From: Simon Davis
Sent: 22 July 2022 13:48
To: Lisa Jackson [REDACTED]
Subject: RE: National Highways response: Y/3/22/OUT, Land West of Bilsham Road, Yapton

For attention of:	Mr Thomas Moloney
Site:	Land West of Bilsham Road Yapton
Proposal:	Hybrid Application comprising of: Outline planning application for further phases of up to 110 No dwellings and associated infrastructure (with all matters reserved) and Full application for Phase 1 for 30 No residential dwellings, new access from Bilsham Road, public open space, landscaping, sustainable urban drainage and associated works. This application is a Departure from the Development Plan and is in CIL Zone and is CIL Liable as new dwellings.
Your Reference:	Y/3/22/OUT
National Highways' Reference:	93768 #17191(SB379)

We have received your technical note A361-TN008 and associated plans following our earlier correspondence with yourself and Arun District Council regarding the detail of the Transport Assessment and subsequent technical notes A361-TN005 and A361-TN007 Rev A.

Appendix C – A27 Mitigation Scheme

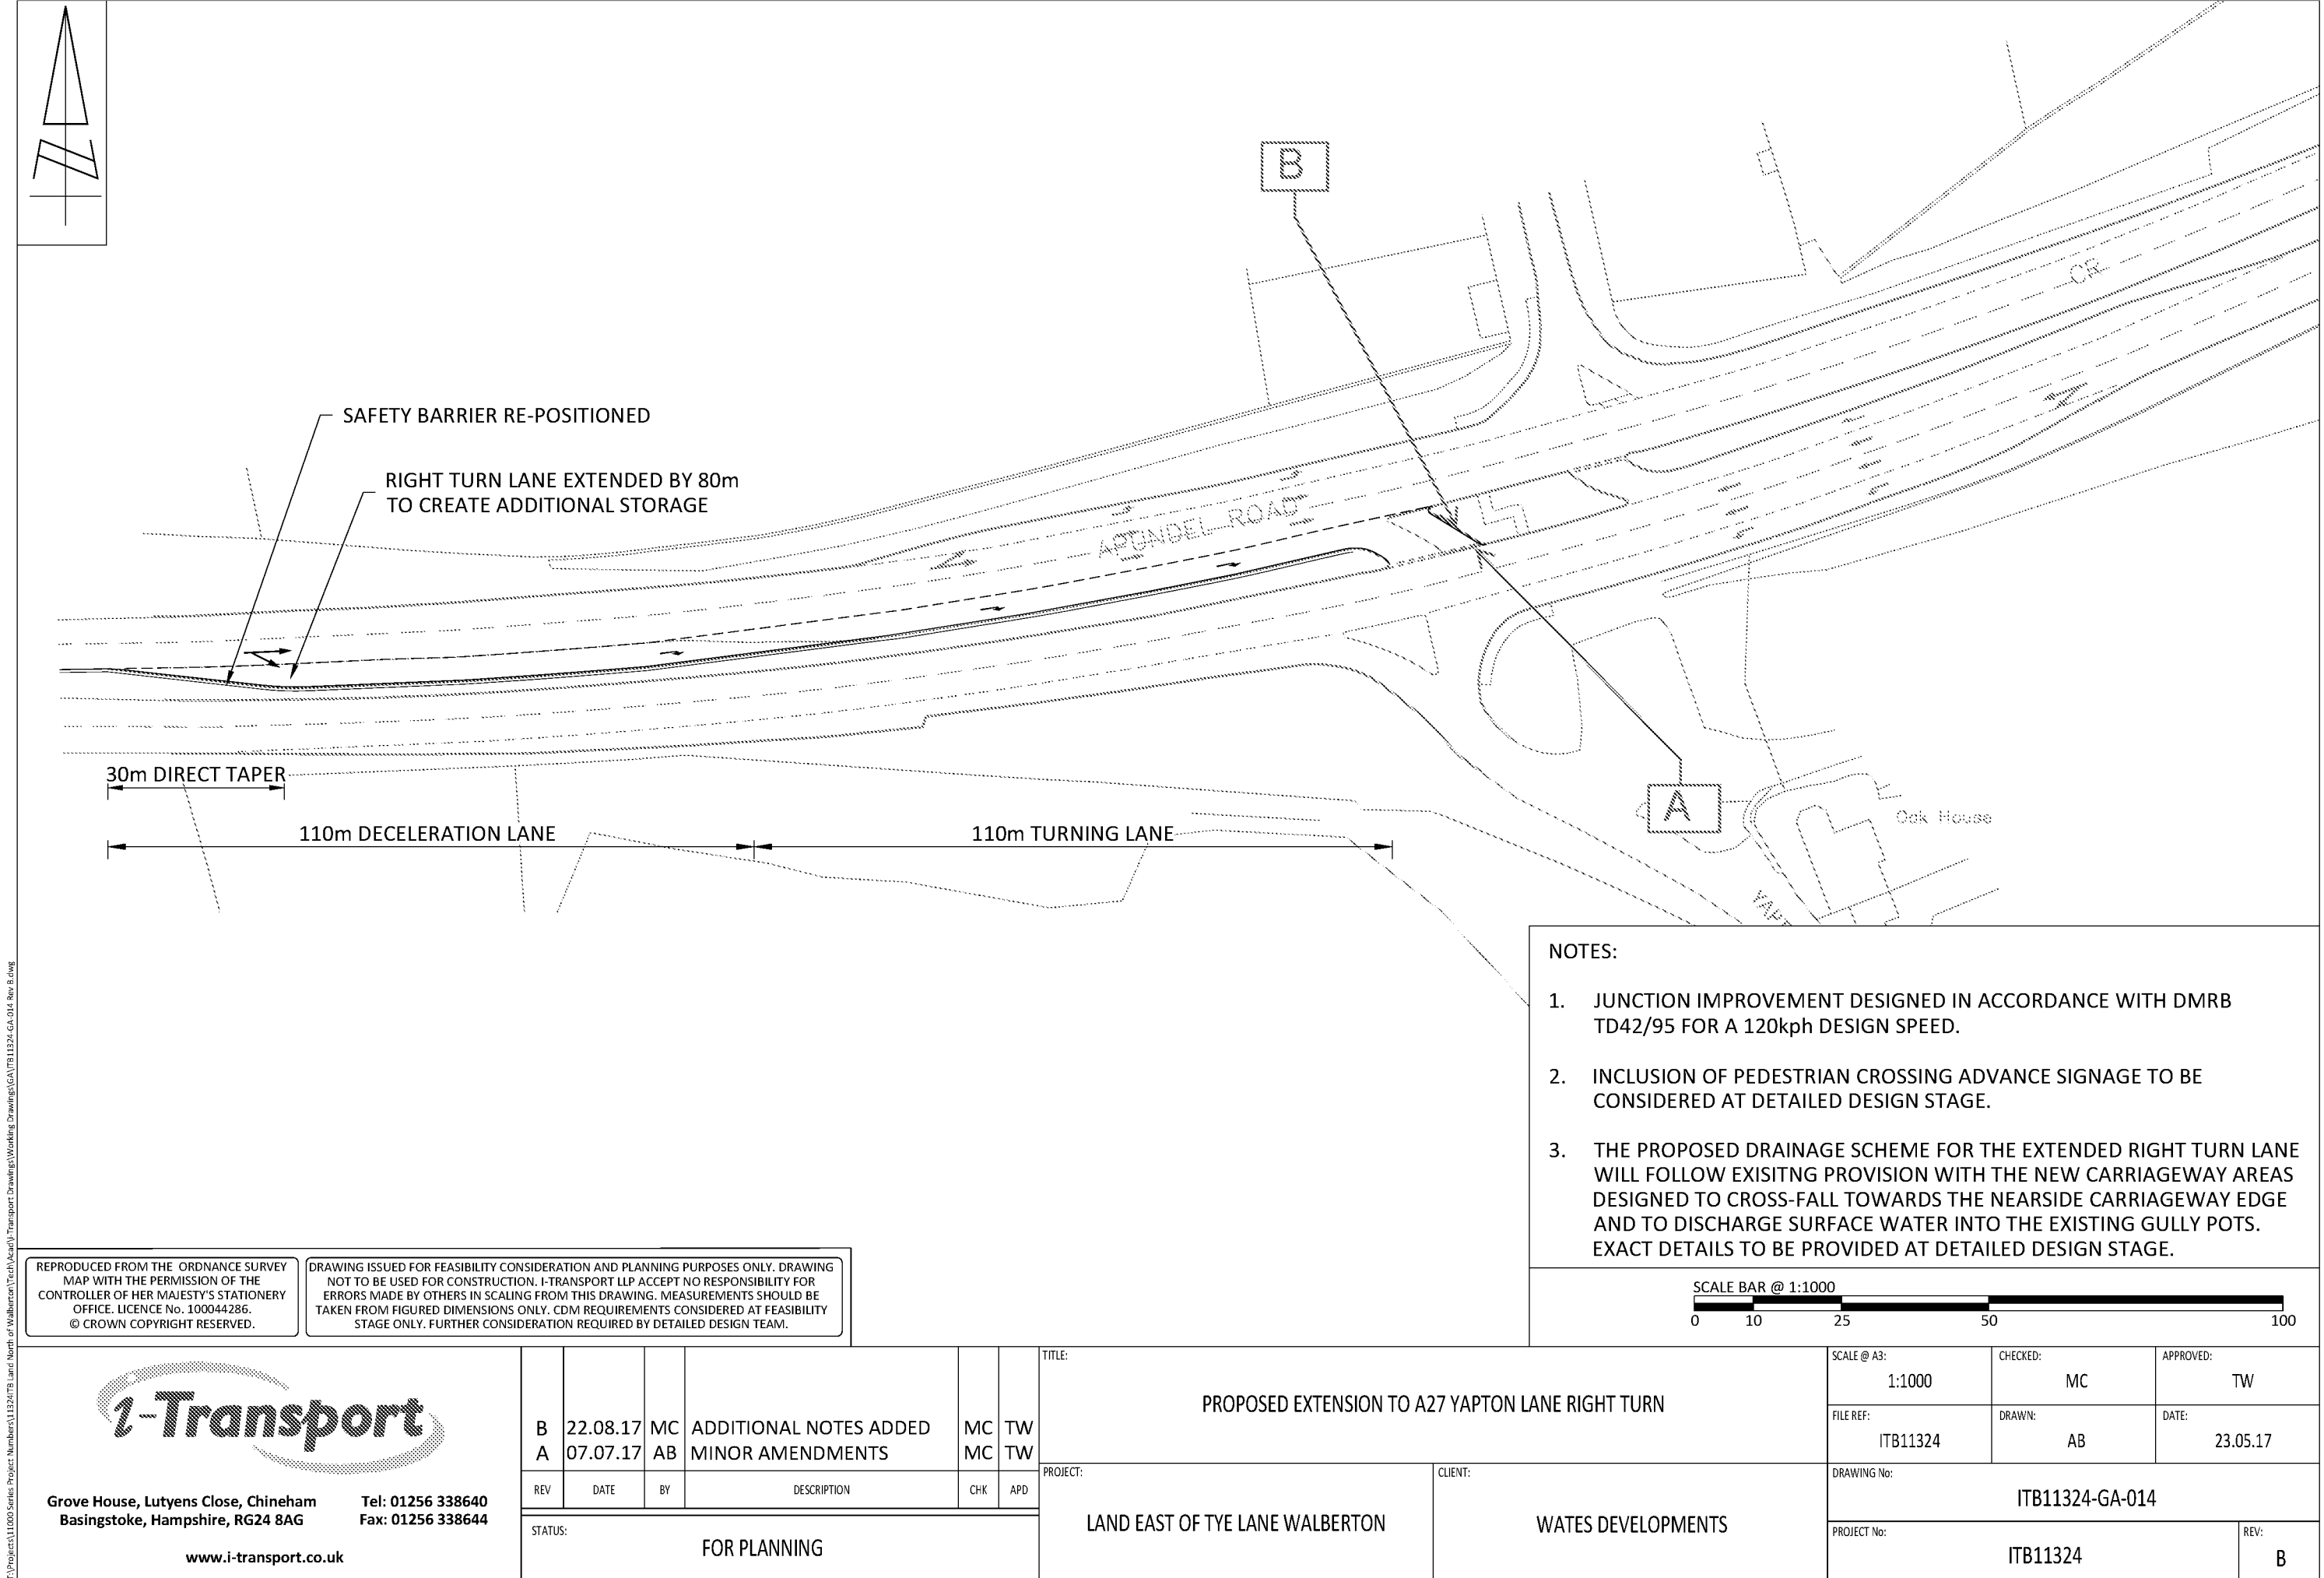
We observe that the model outputs for the improvement scheme layout have only been provided for the PM peak period; the outputs for the AM peak period also need to be provided so that the general performance of the improved junction in this period can be verified.

ACTION: AM peak model files for the improvement scheme layout as shown on drawing number ITB11324-GA-014 Revision C need to be provided.

1. Traffic Impact Assessment - Temprow calculation - the information NH are requesting is academic (and has been provided previously) as the impact is not significant. This is only an exercise to look at the figure in a different format and it does not change the overall outcome.
2. Mitigation Scheme - The AM peak was not previously raised by NH as a concern as this is about the queue in Yapton Lane (not the A27) the latter would be the remit of WSCC (who have raised no objection). We are confident that this issue would not justify the holding objection by NH.
